Our ref: NO/2019/111994/01-L01
Your ref: 3/2019/0356
Date: 16 September 2019

DEMOLITION OF EXISTING FARM HOUSE AND ERECTION OF REPLACEMENT DWELLING. CHANGE OF USE OF BARN TO ONE LIVE/WORK UNIT INCLUDING CONVERSION OF AN EXISTING BUILDING TO GARAGE. DEMOLITION OF EXISTING FARM BUILDINGS. (RESUBMISSION OF APPLICATION 3/2018/1081). STARTIFANTS FARM GOOSE LANE, CHIPPING, PRESTON, PR3 2QB.

We object to this planning application due to an inadequate FRA

Client Details:
Mr & Mrs. R. Robinson
Project Date:
Proposed site plan.

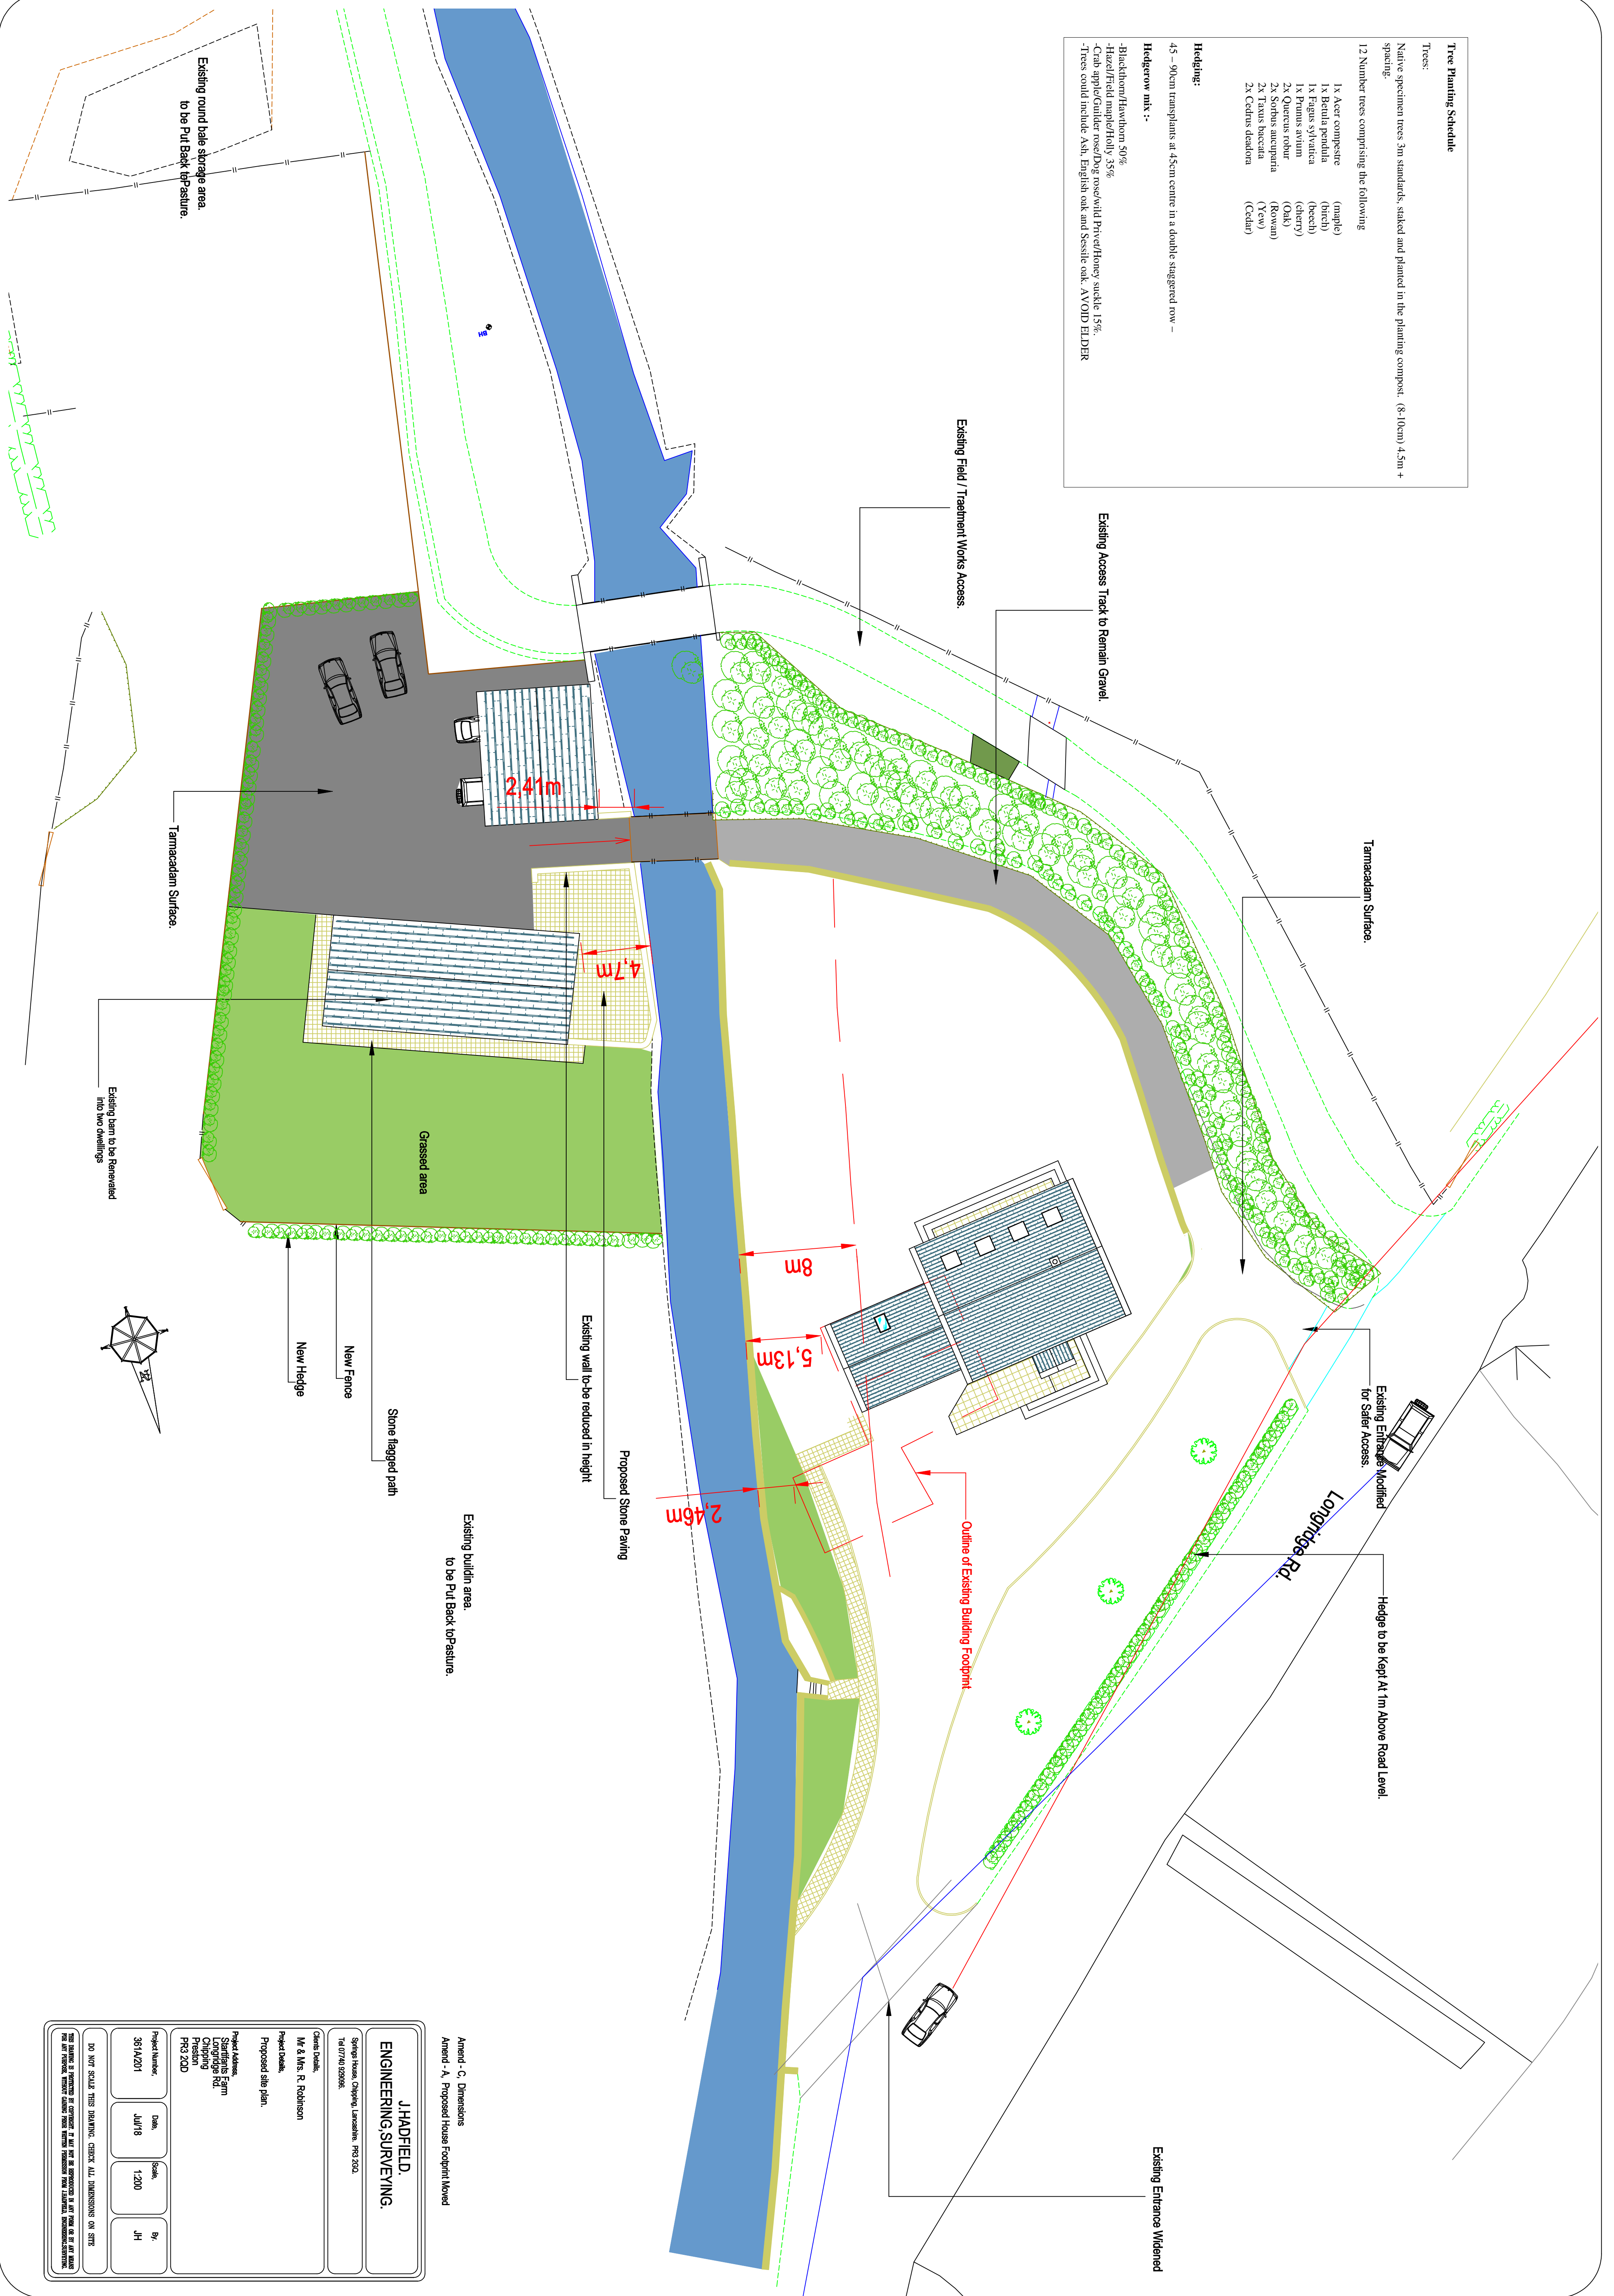
- * For the proposed widening/ changing of the line of the drive off Longridge Road alongside the watercourse: The FRA has not made it clear how close to the top of the bank of the watercourse this will be located and how the widened drive will be supported.

- * For the proposed replacement farm house: The FRA has not made it clear where the house and paving around it is located in relation to the top of the bank of the watercourse

- * The FRA has not made it clear whether or not there is any work proposed to the bridge across the Main River
- * There are a number of buildings on the left bank which are to be demolished, the FRA has not made it clear how far these are from the top of the bank of the watercourse. Their demolition may cause instability to the bank of the watercourse, therefore an Environmental Permit may be required

- * The new hedge and fence alongside the grassed area next to the live work unit appears to be within the 8 metre easement and will therefore require an environmental permit.

The FRA should clearly show/state how close to the top of the bank of the watercourse these activities are taking place and consider the need for Environmental Permits for all/some of them.
